Zoning Division
Marge Schmuckal
Zoning Administrator

December 12, 2002

RE: 100 Congress Street – 016-D-001 –permit appl. #02-1335 – B-1 zone

J. Roger Trettel  
42 North Street  
Portland, Maine 04101  
Site Plan for:  
100 Congress Street  
Cafe Space

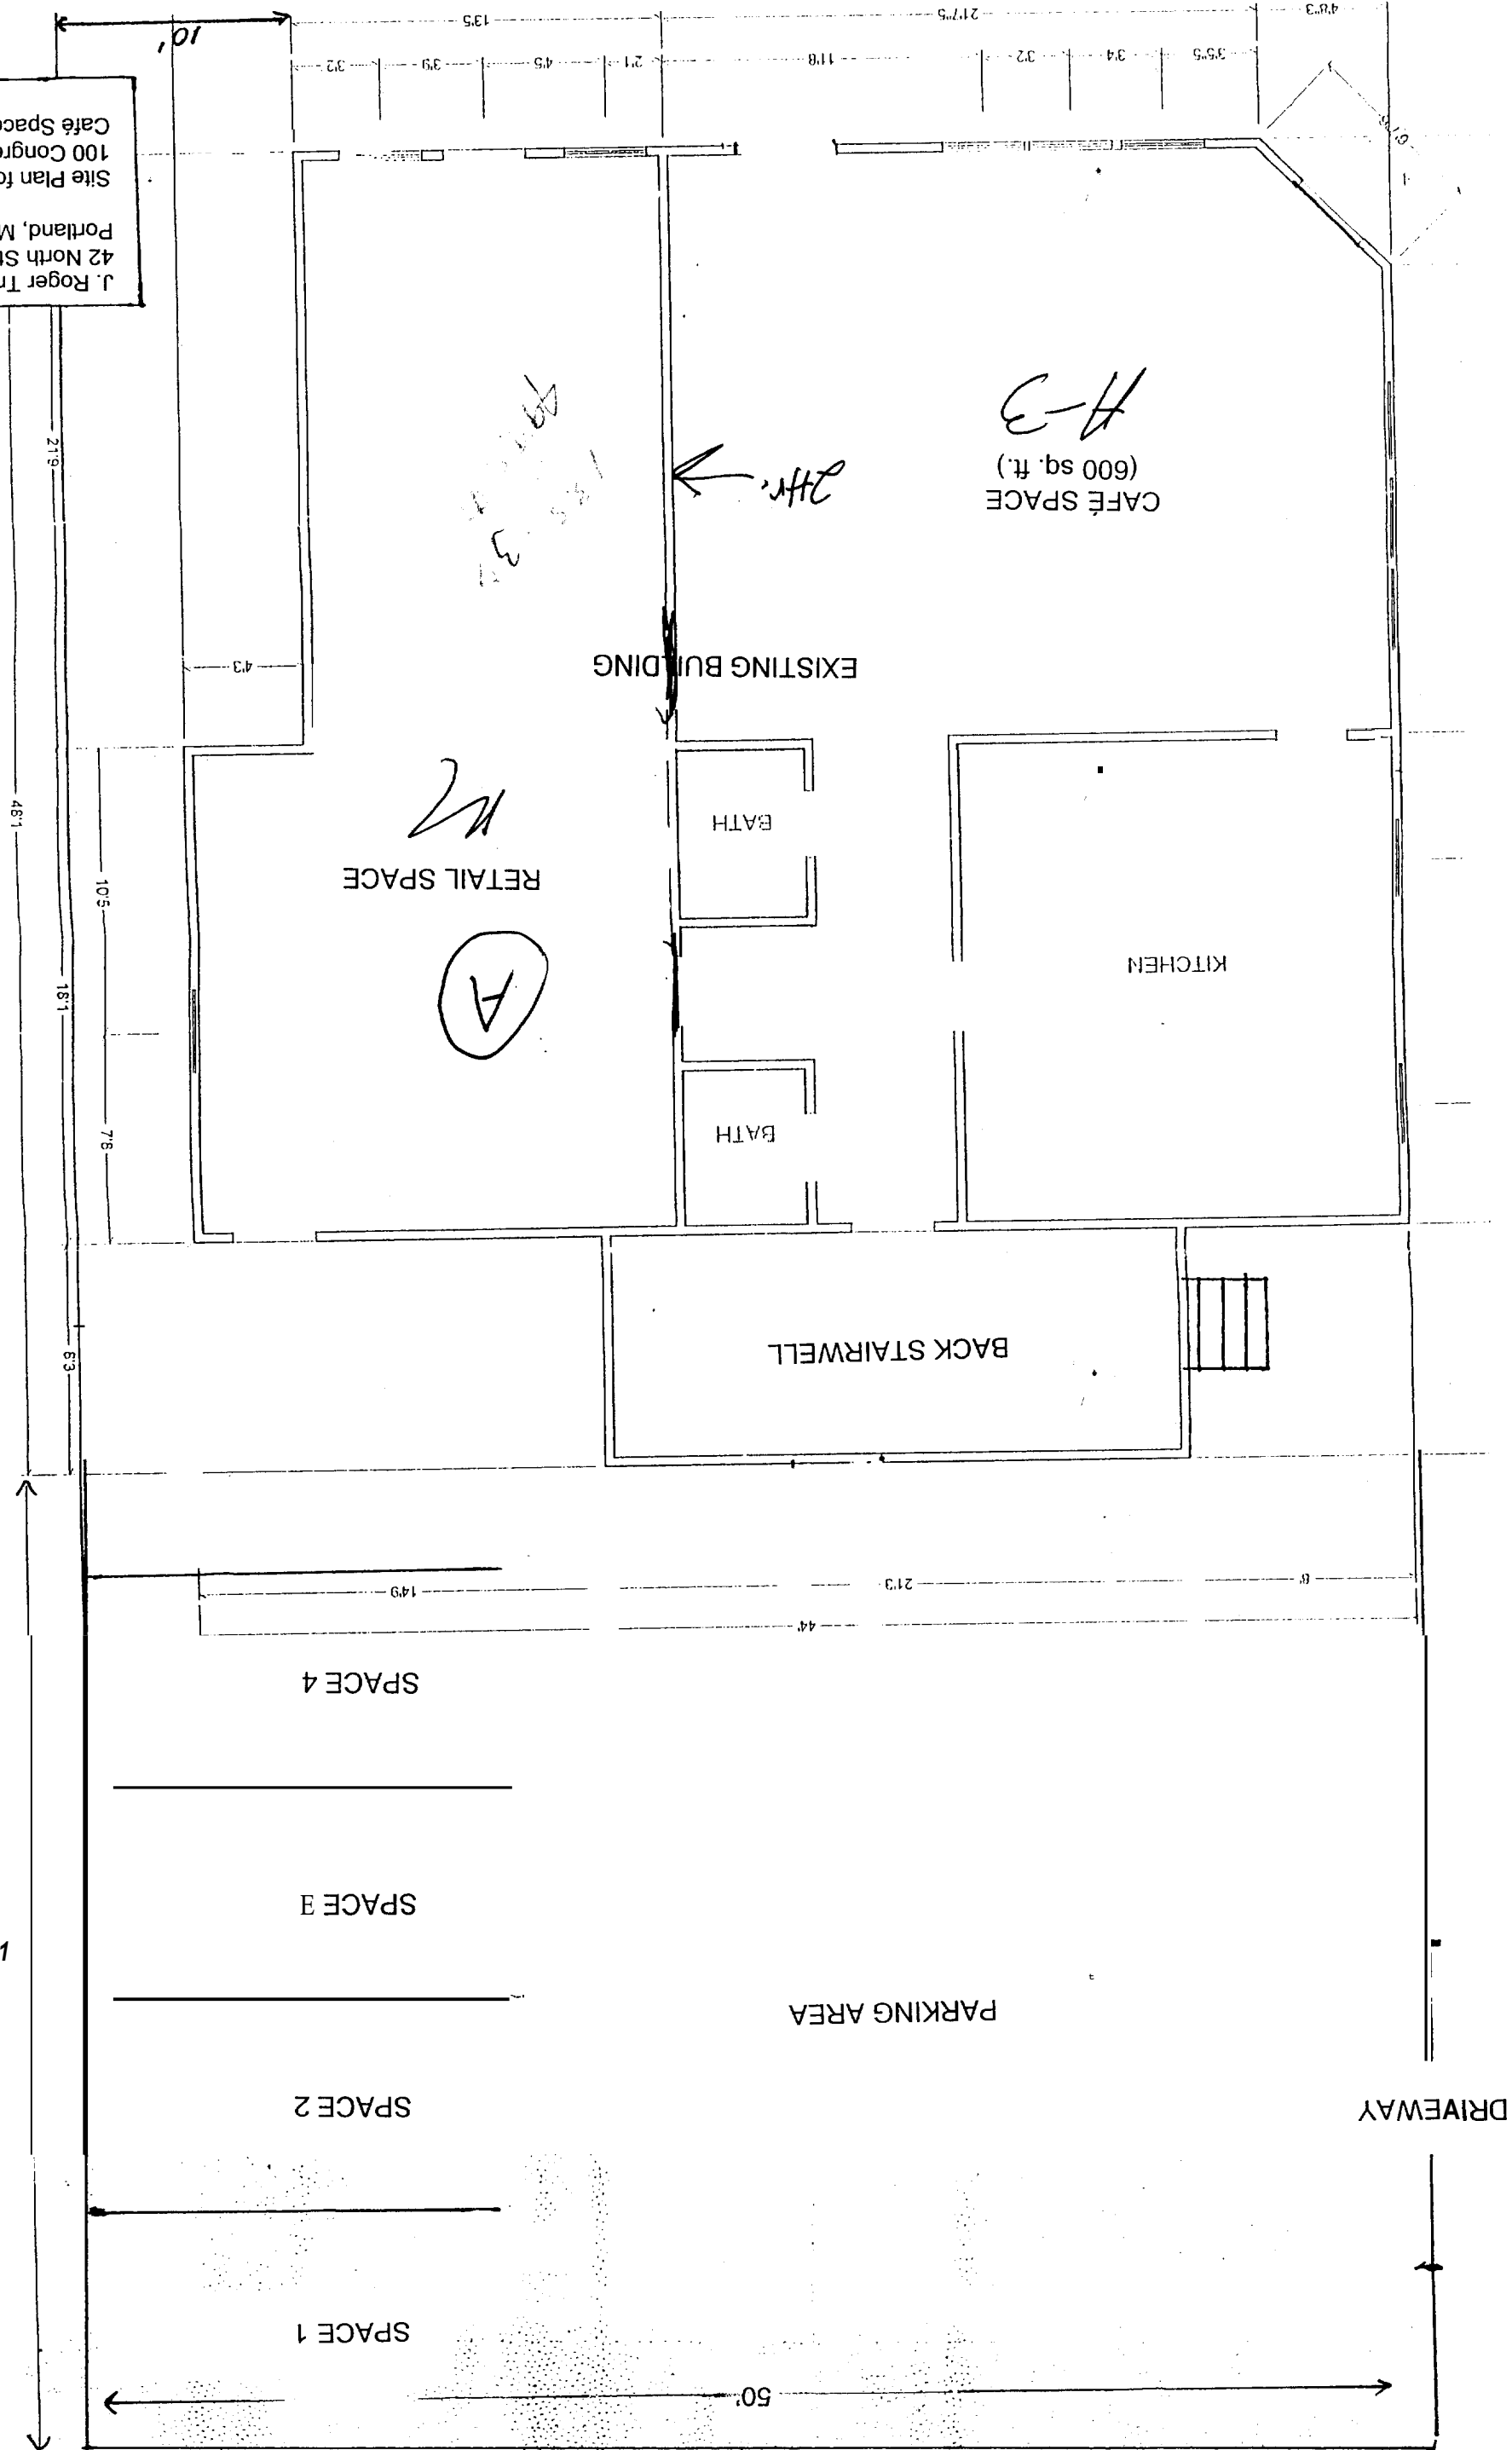
I am in receipt of your application permit to expand your restaurant at 100 Congress Street. As you may remember, previously when the restaurant was created, you needed to go thru a site plan review. A copy of that approval is attached. One of the main issues was parking. A restaurant use requires one (1) parking space for each 150 square feet of area, not including the kitchen area or bulk storage areas. A quick tally of your total square footage on the floor plan that you submitted for your present expansion shows that you have 900 square feet of area. This requires 6 parking spaces. Your present submittal shows no site plan showing any parking.

Before this office can further process your permit, you would need to contact the Planning Division (Bill Needleman was your previous reviewer) and apply for an amendment to your site plan approval. Both offices, Planning and Zoning, shall require a site plan showing your required parking.
